The Woodland Trust
Kempton Way
Grantham
Lincolnshire
NG31 6LL

15th February 2022

Reference: A47 Wansford to Sutton Written Representation

ADAS, 11d Park House, Milton Park,
Milton, Abingdon, Oxford, OX14 4RS
Tel: 01235 355630
© RISK ADAS Ltd.

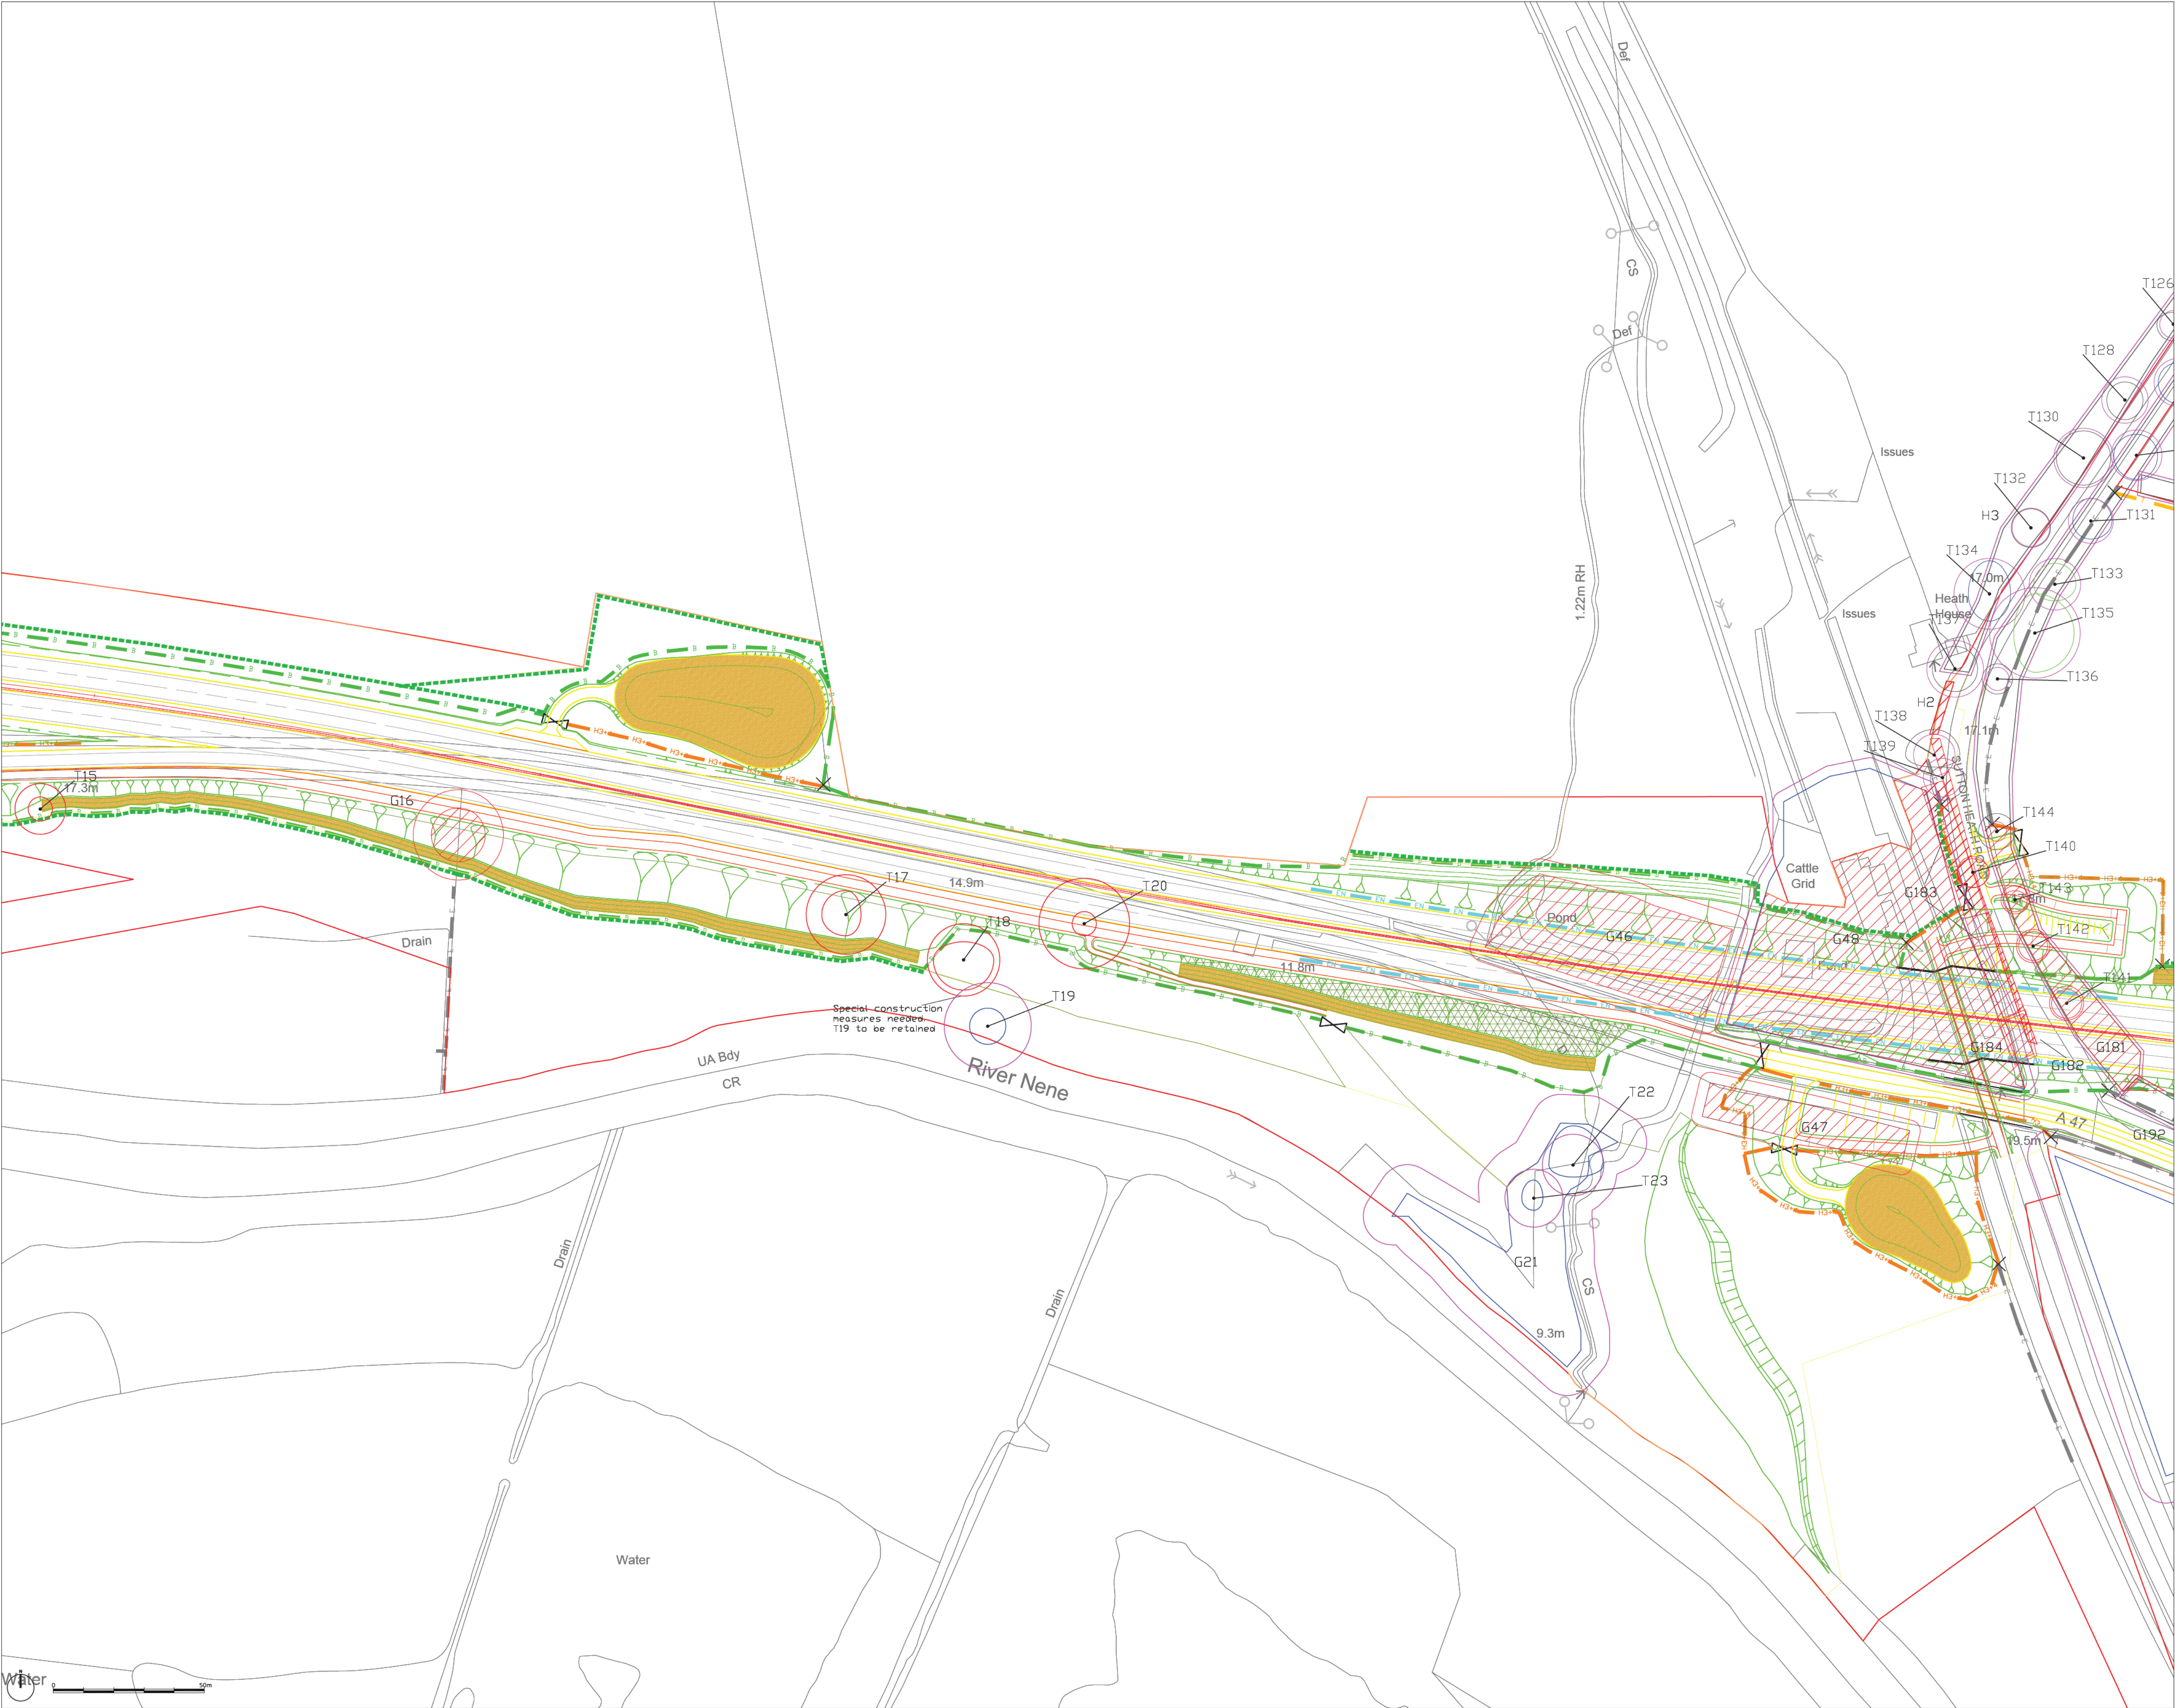
The proposed scheme will result in the loss of a veteran oak tree recorded as T20 within the Arboricultural Impact Assessment report [APP-096]. Therefore, the Trust would like to lodge **an objection** to this development.

The following scheme will result in the direct loss of a veteran oak tree (T20) to facilitate the new carriageway. Natural England’s standing advice for ancient woodland and veteran trees states: *“Direct effects of development can cause the loss or deterioration of ancient woodland or ancient and veteran trees by:*

Natural England’s standing advice for protecting veteran trees is as follows: *“For ancient or veteran trees (including those on the woodland boundary), the buffer zone should be at least 15 times larger than the diameter of the tree. The buffer zone should be 5 metres from the edge of the tree’s canopy if that area is larger than 15 times the tree’s diameter. This will create a minimum root protection area. Where assessment shows other impacts are likely to extend beyond this distance, the proposal is likely to need a larger buffer zone.”* The Trust requests that the applicants retain T20 and provide a suitable buffer zone as befitting a veteran specimen.

In summary, the Woodland Trust requests that veteran tree T20 is retained and afforded a Root Protection Area (RPA) in line with Natural England’s standing advice.
